Date: 25-Apr-2023  
Our Ref: 2023/90682

**TOWN AND COUNTRY PLANNING ACT 1990  
TOWN AND COUNTRY PLANNING (GENERAL PERMITTED DEVELOPMENT)  
(ENGLAND) ORDER 2015 (as amended), SCHEDULE 2, PART 3, PART MA  
NOTIFICATION OF PROPOSED CHANGE OF USE CLASS MA – COMMERCIAL,  
BUSINESS AND SERVICE USES TO DWELLINGHOUSES  
APPLICATION NUMBER: 2023/90682  
AT: 21, St John's Road, Huddersfield, HD1 5BW**

**Prior approval of a proposed change of use of a building from commercial, business and service uses to dwellinghouses**

Description
FLOOR PLANS AS PROPOSED

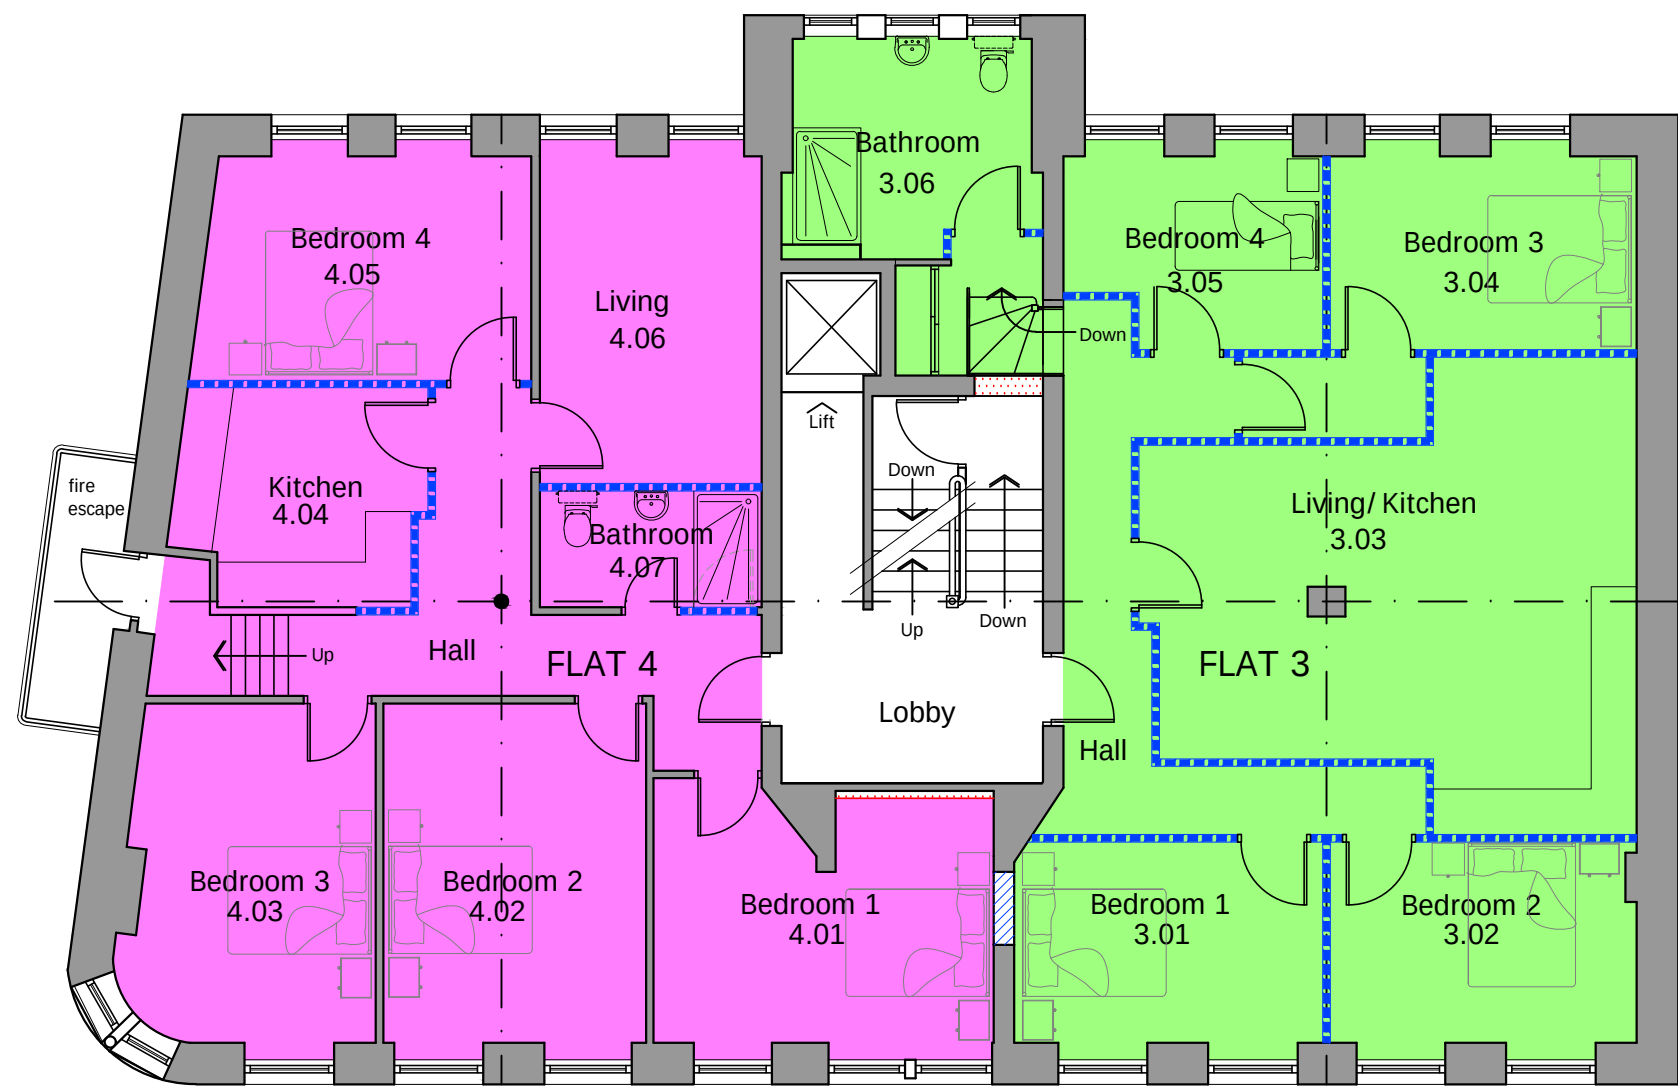
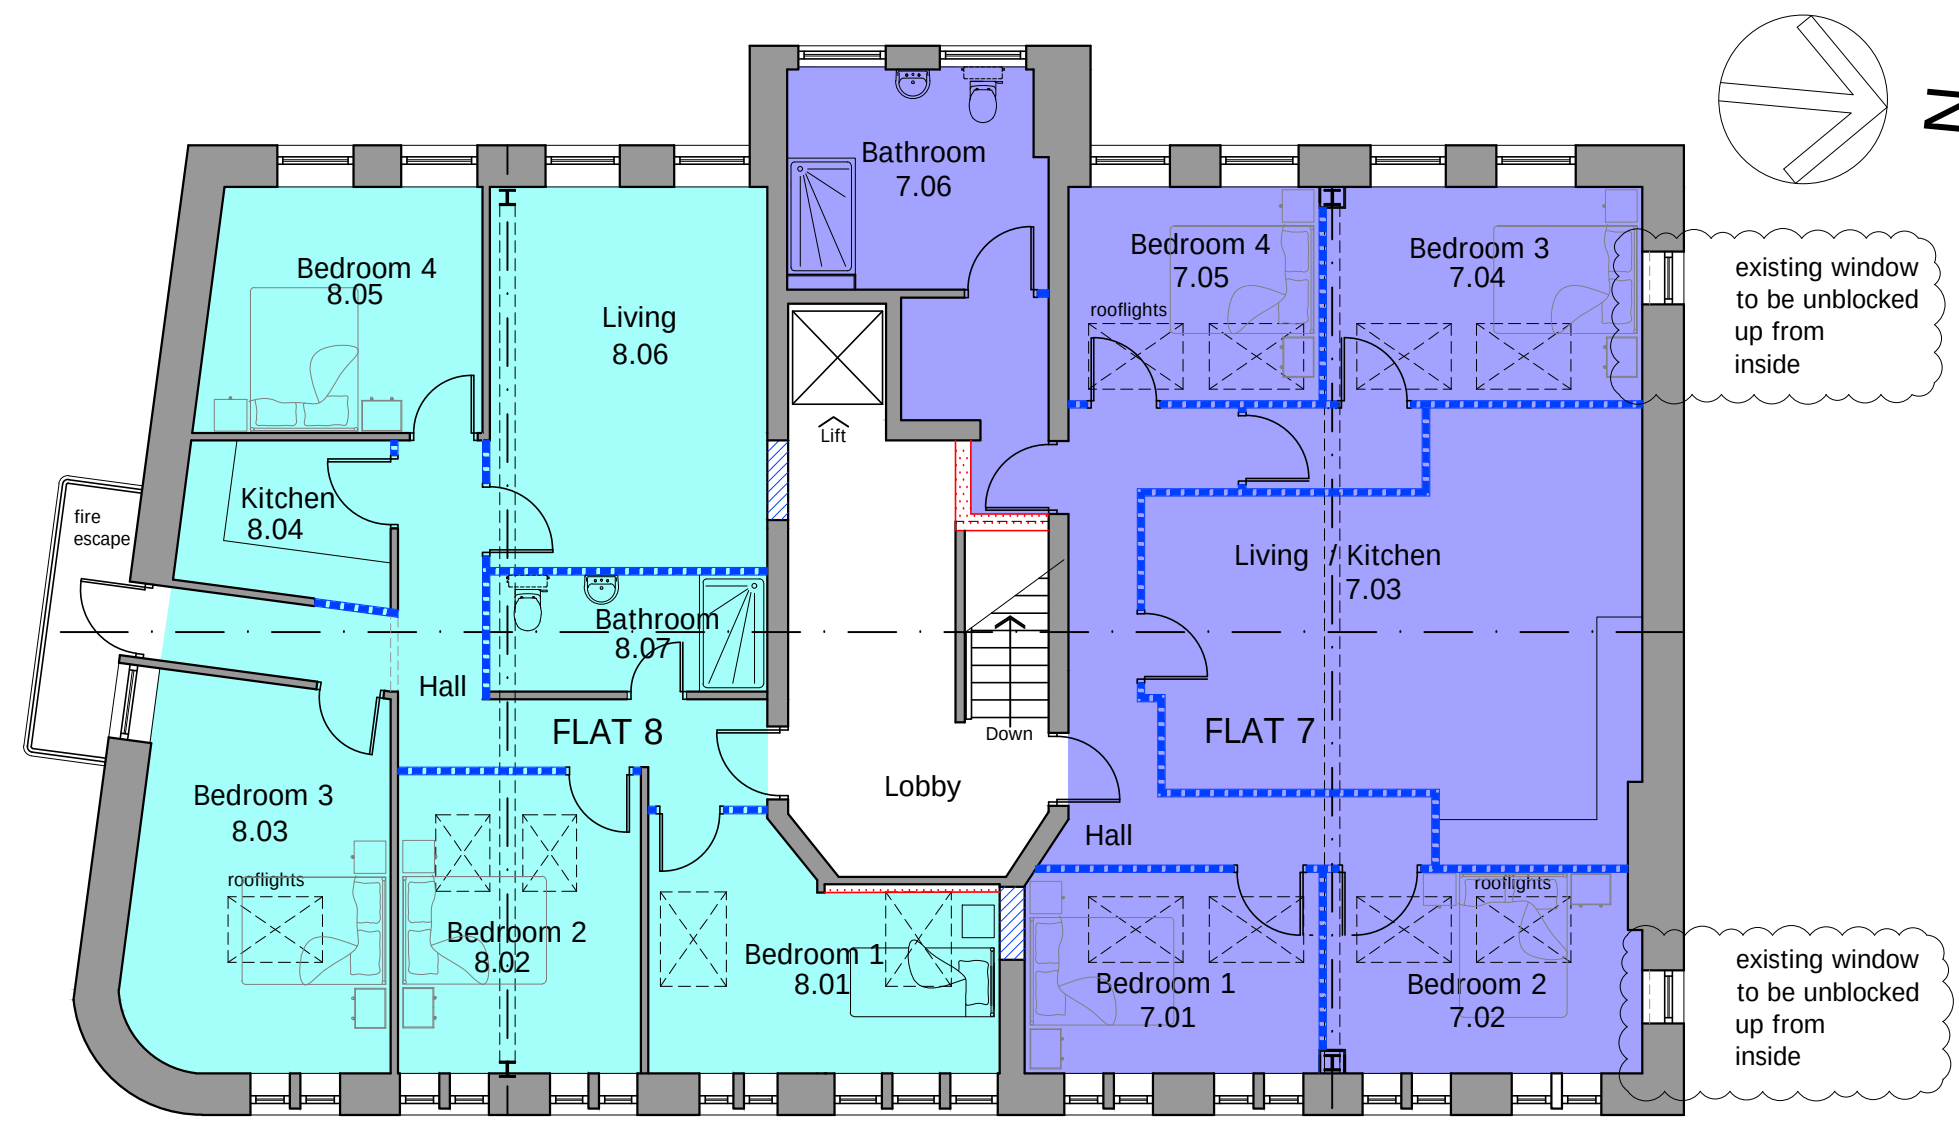
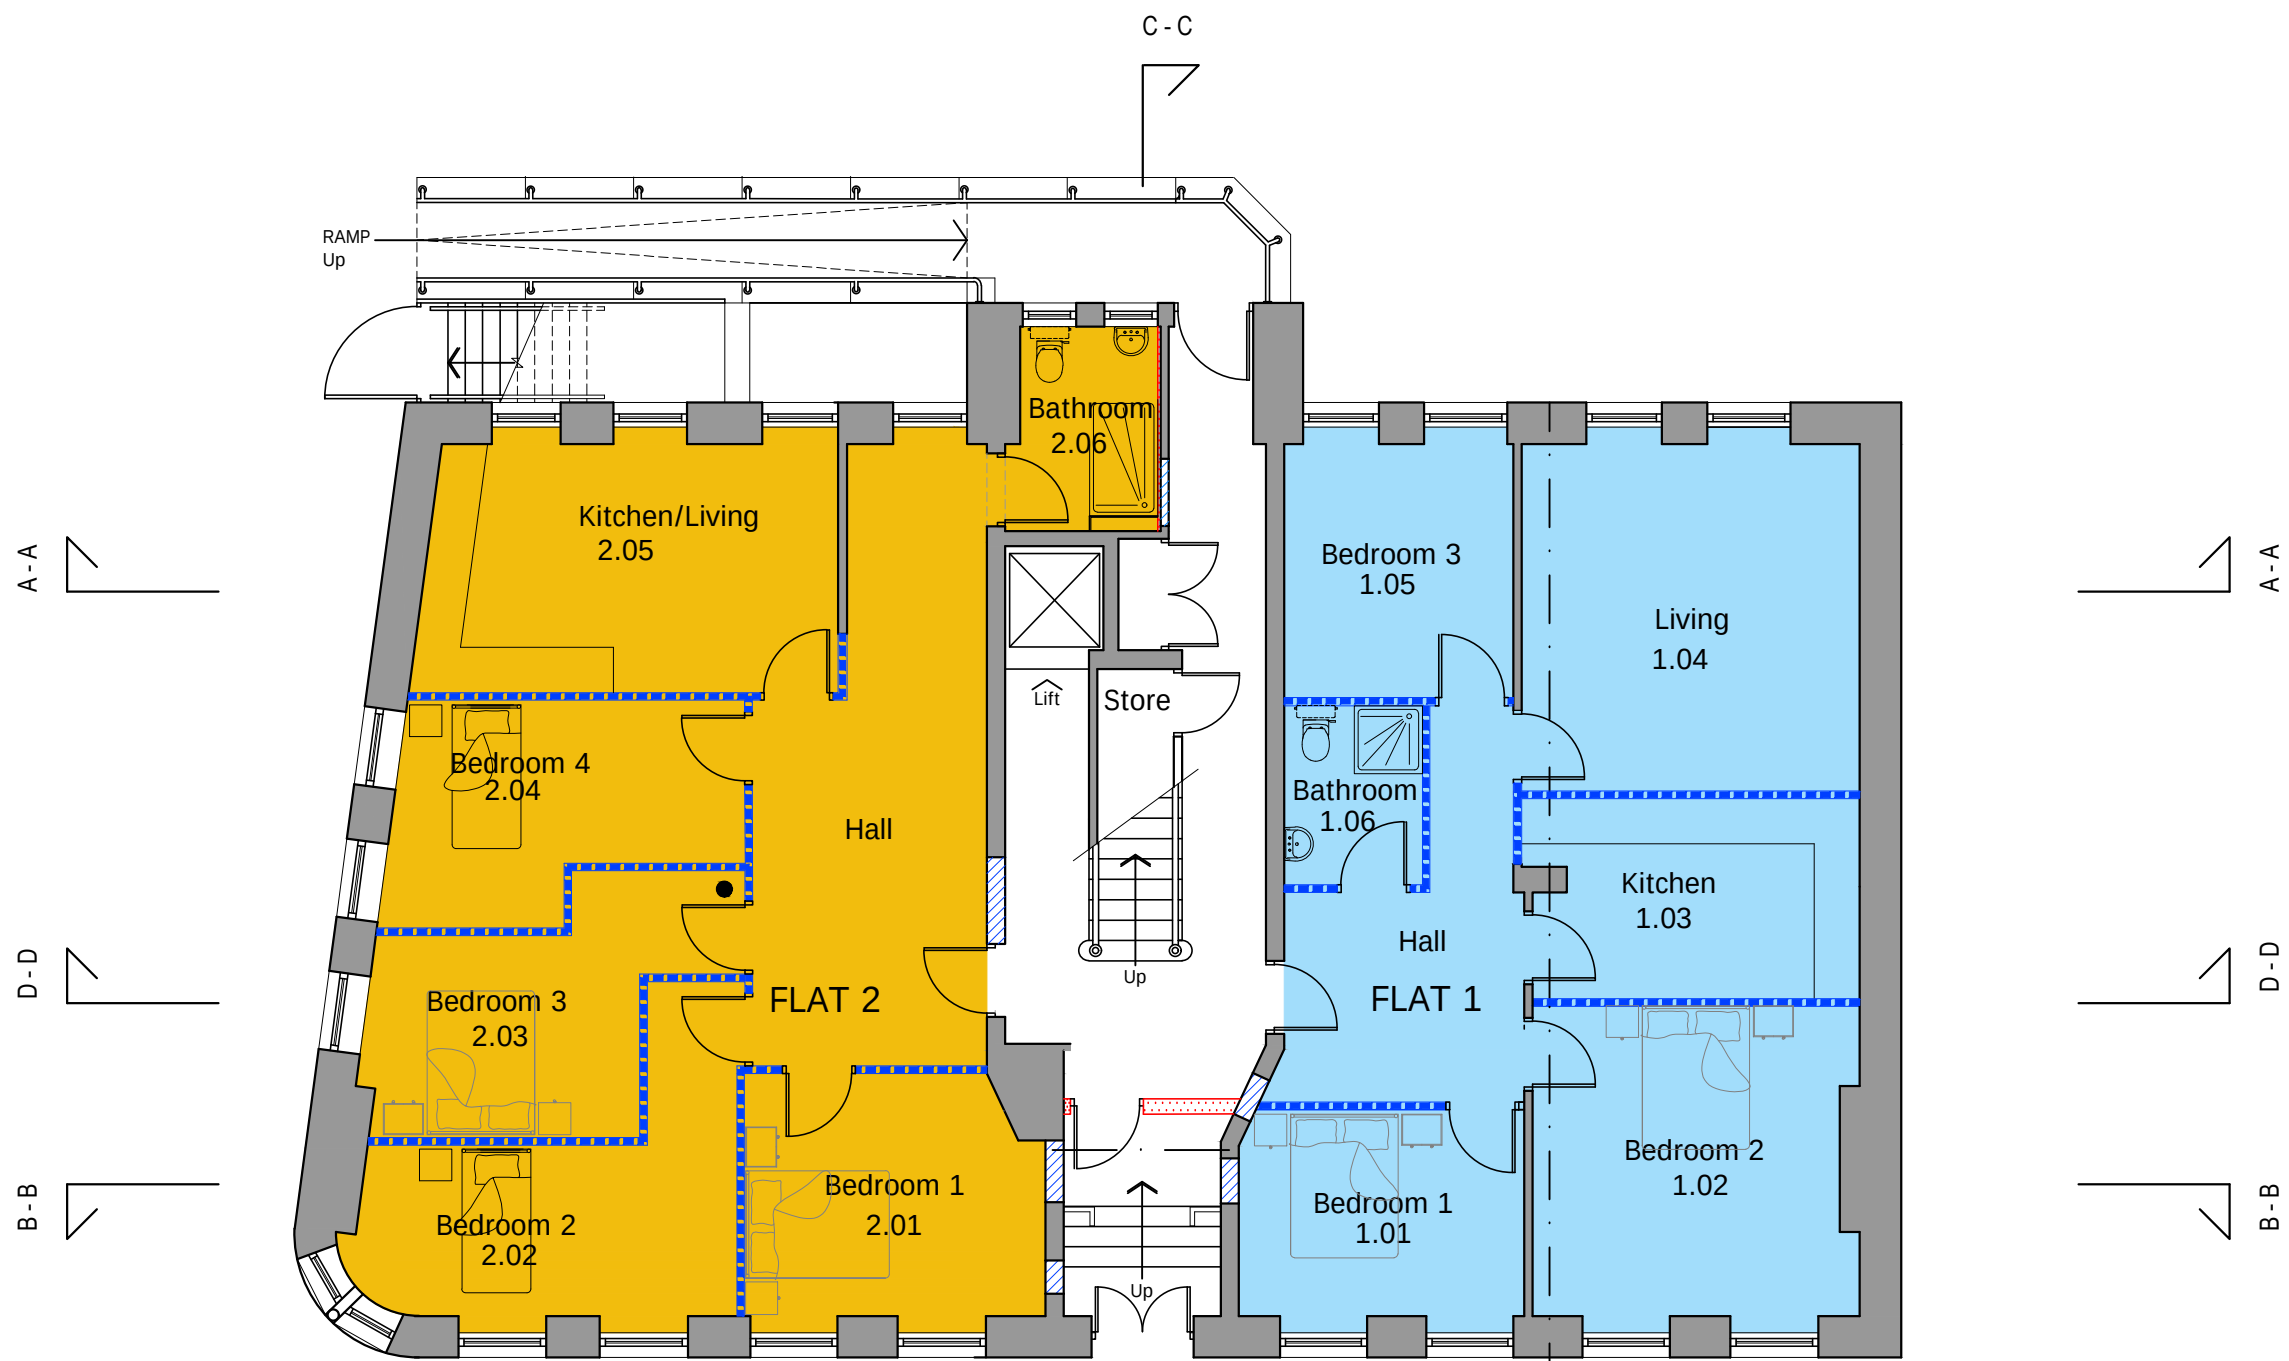
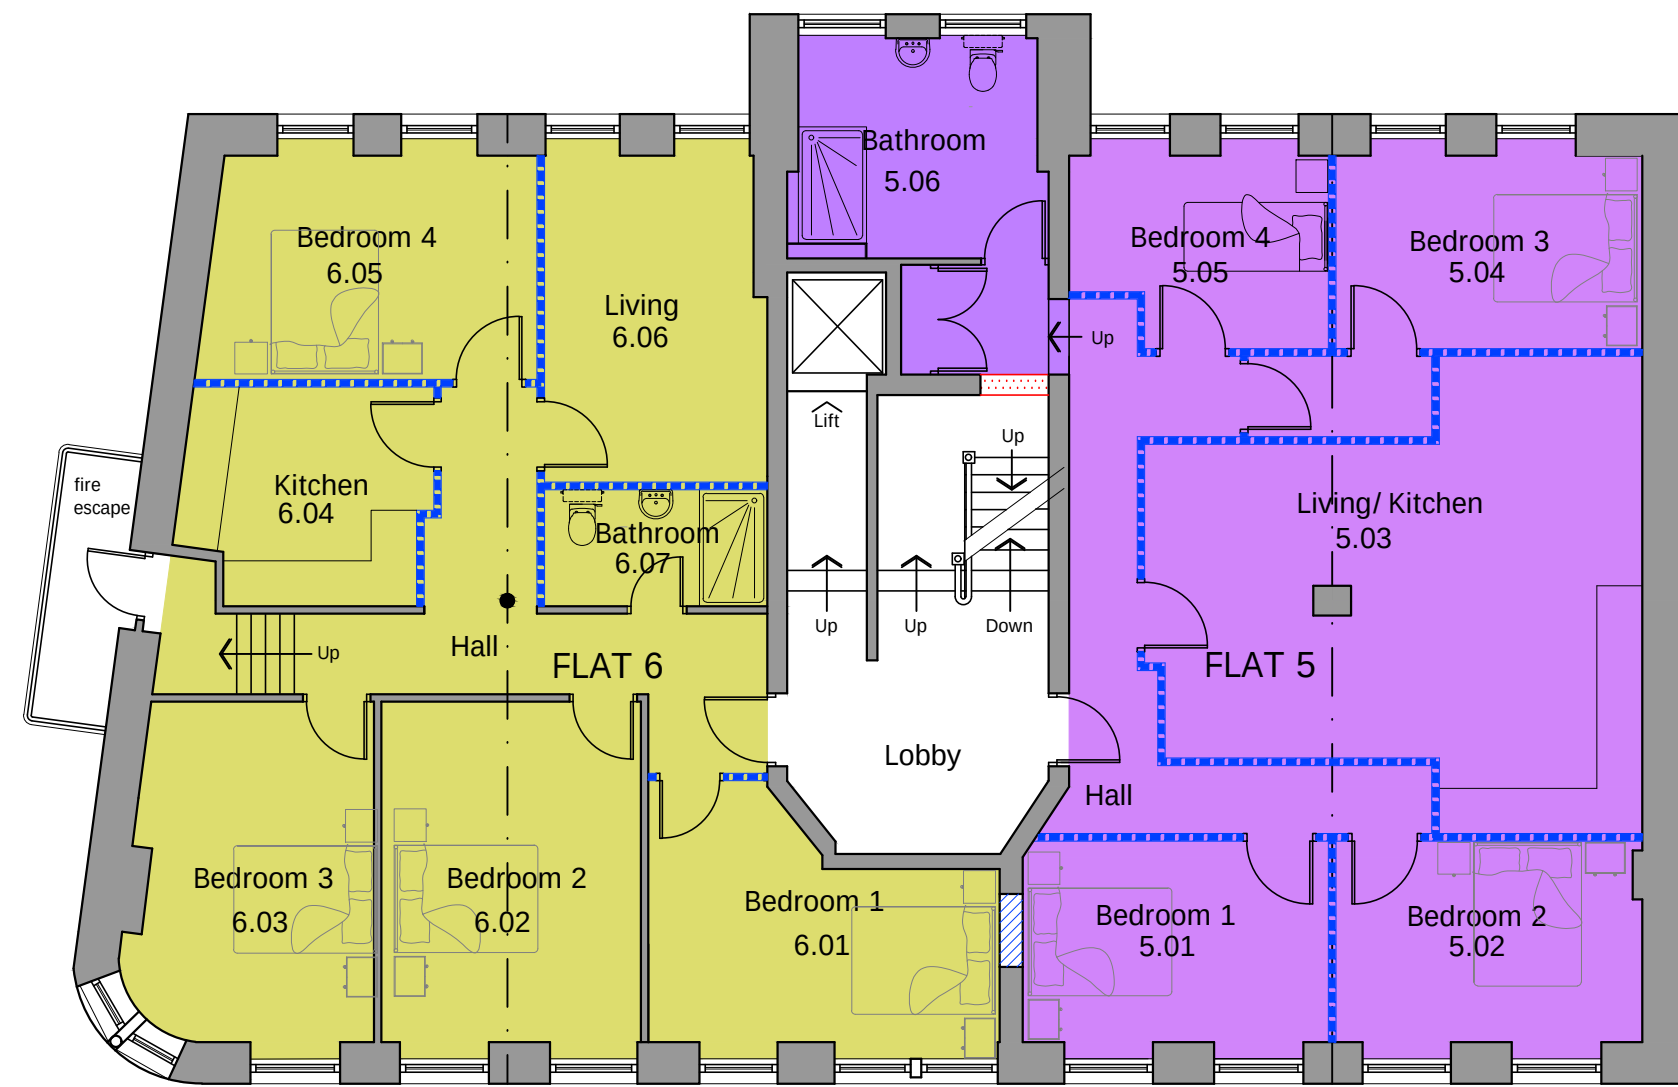
The proposal would fail to comply with requirements as set out by the Town and Country Planning (General Permitted Development)(England) Order 2015 (as amended) Article 3(9A) by not meeting the required space standards.

Part 2A of Part 3, paragraph W of the Town and Country Planning (General Permitted Development)(England) Order (as amended) states that the local planning authority must refuse prior approval if adequate natural light is not provided in all the habitable rooms of the dwellinghouse. In this instance it is considered inadequate natural light is provided into communal living spaces within flats 3, 5 and 7.
